Playing Field Study

Project Ref: 22315
ALA Project Ref: ALA823 New Woodley School
Client: Kirklees
Date: 21.01.2025

This letter provides a response to Sports England's comments on the planning application for a Special Educational Needs School (reference 2024/91998) at the Former Almondbury High School, Fernside Avenue, Huddersfield, HD5 8PQ.

DRAWING TITLE:
Landscape Illustrative Masterplan

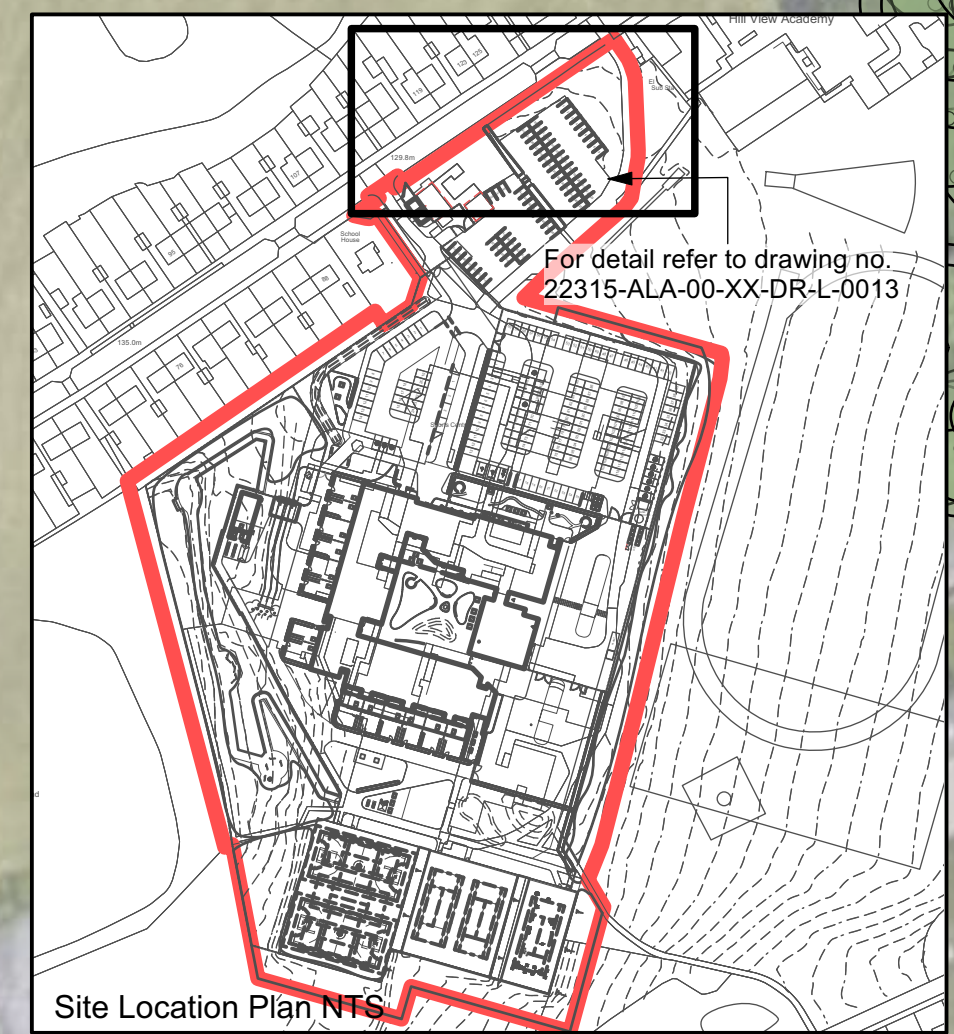
The submitted Illustrative Landscape Masterplan shows this area of the site used as a 'Forest School Play Space' which is a form of outdoor sports facility. This physical sporting activity is tailored to the specialist use of the site as a Special Educational Needs School for children and young people with Autism. This will provide a type of sporting activity that is significantly beneficial to children and young people with Autism.

Therefore, the proposed development also meets **Exception 5** for the development of sports pitches as set out in Sports England Guidance.

Ball Stop Netting Layout

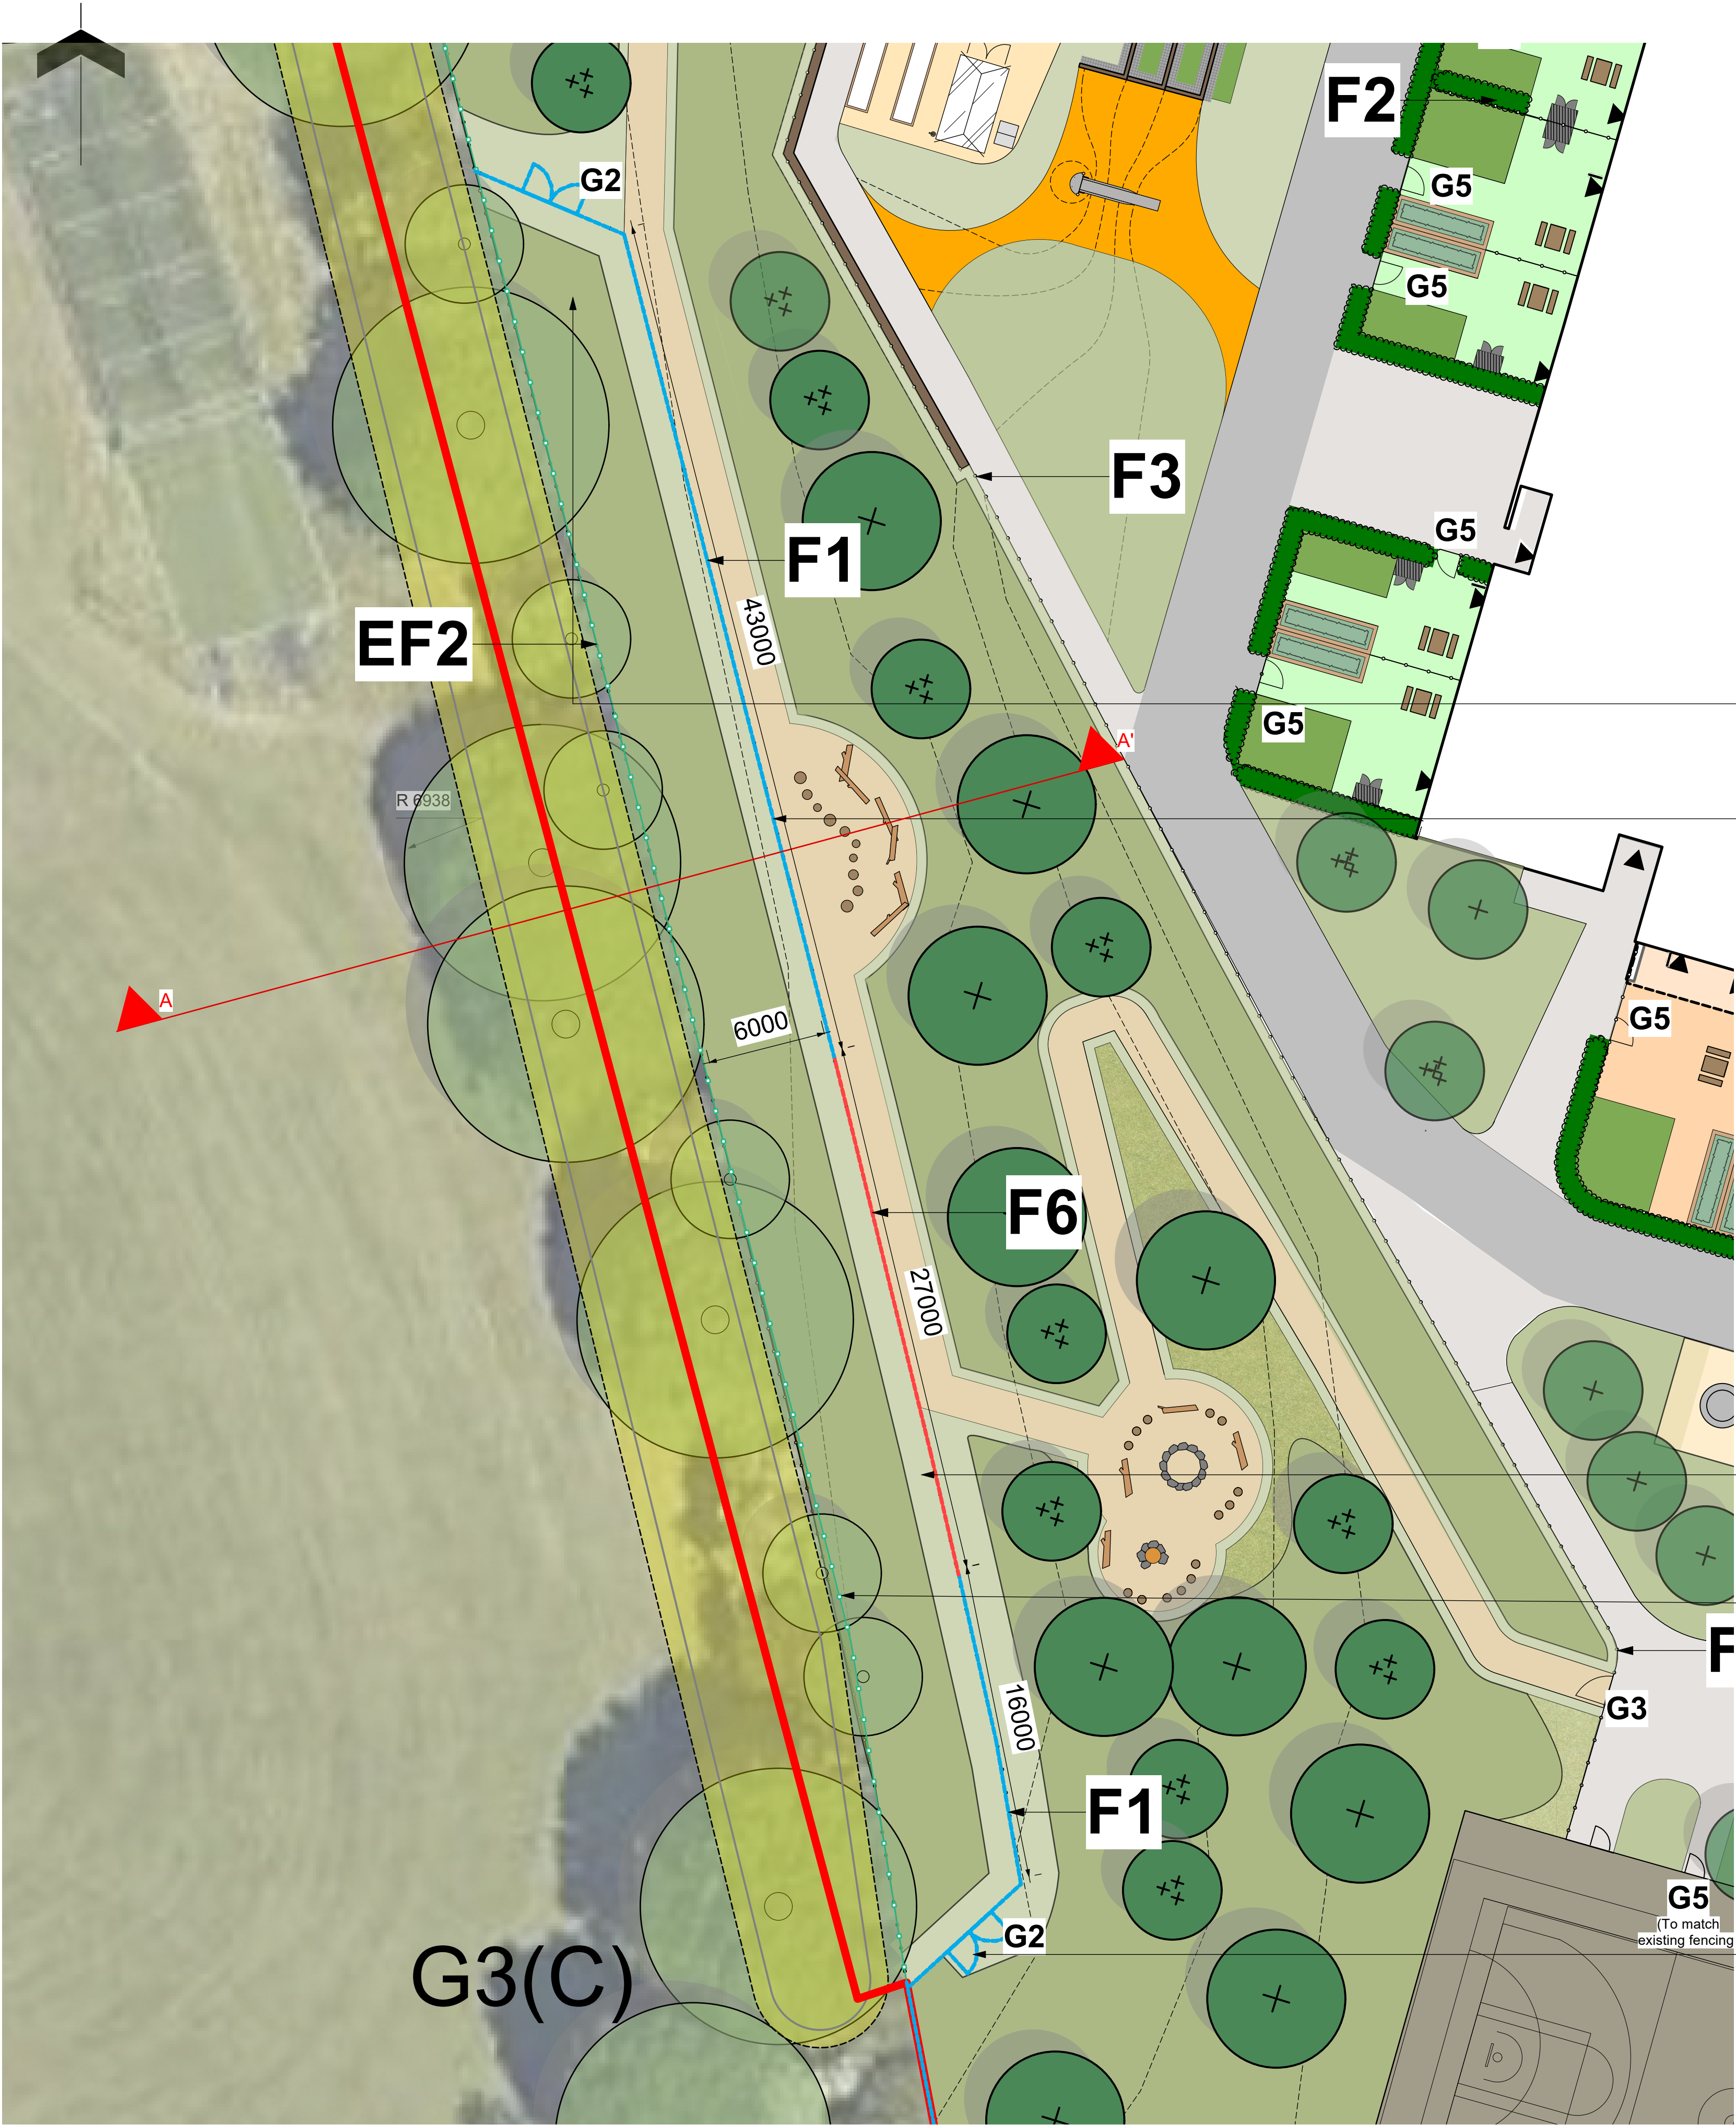
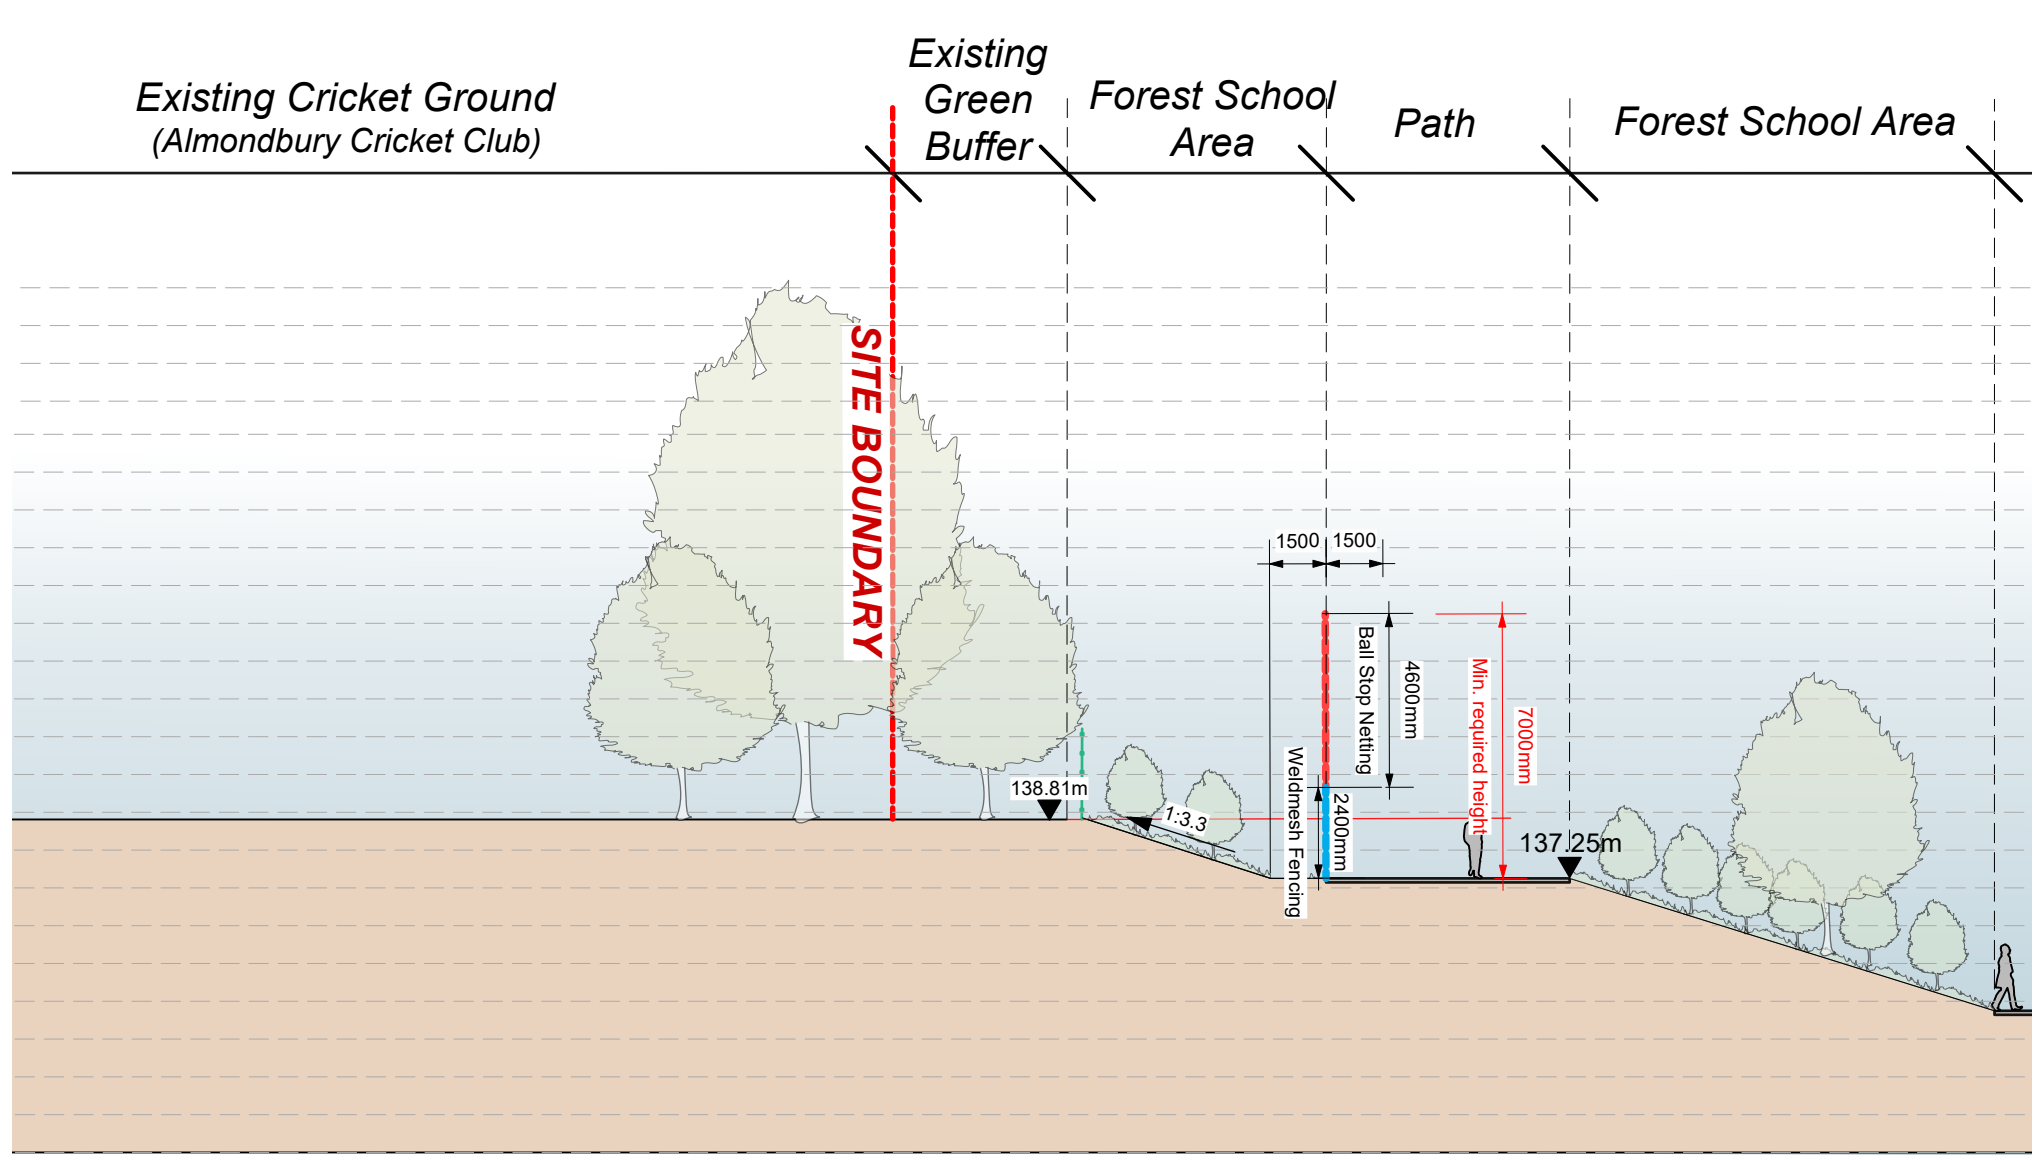
- *Point 1: The loss of playing field to the west of the existing buildings.*
- *Point 2: The loss of the tennis court.*
- *Point 3: The impact on the playing field to the east of the existing buildings.*
- *Point 4: Ball strike.*

Point 4: Ball Strike

Response: A ball strike risk assessment has been undertaken by Labosport Ltd who have reviewed the site distances and topography to analyze the risk of balls surpassing the site boundaries of the cricket pitch at Almondbury Cricket Club.

The below diagram (Figure 8) shows the agreed proposed location of the recommended mitigation for a maximum height of 7m, offset from the boundary by 6m.

To be effective during all times of play when there is a risk of ball strike, no access is to be allowed into the area between the cricket square and the ball stop netting fence line.

A proposal has therefore been developed by Ares Landscape Architects which utilises 2.4m high weldmesh perimeter fencing to form the 2.4m boundary requirement (see Figure 9 and Figure 10 for illustrative layout and fencing plan), with retractable ball stop netting to be installed along the 27m extent to a height of 7m as required in Figure 8.

An access controlled area is therefore created between the ball stop netting line and the existing fence line which, available for maintenance to the fence line and vegetation when cricket is not in play.

Indicative example of ball stop netting and weldmesh fencing system

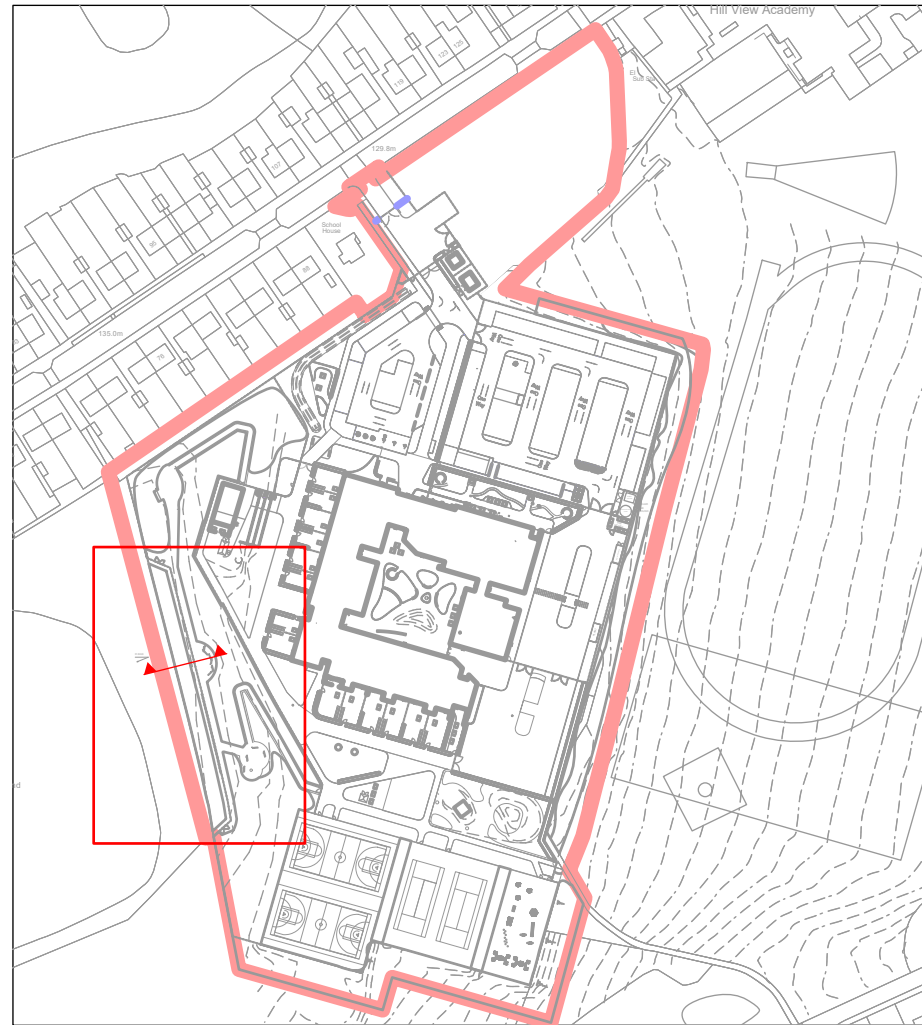
An example of an integrated weldmesh and ball stop netting system is given below (see Figure 11).
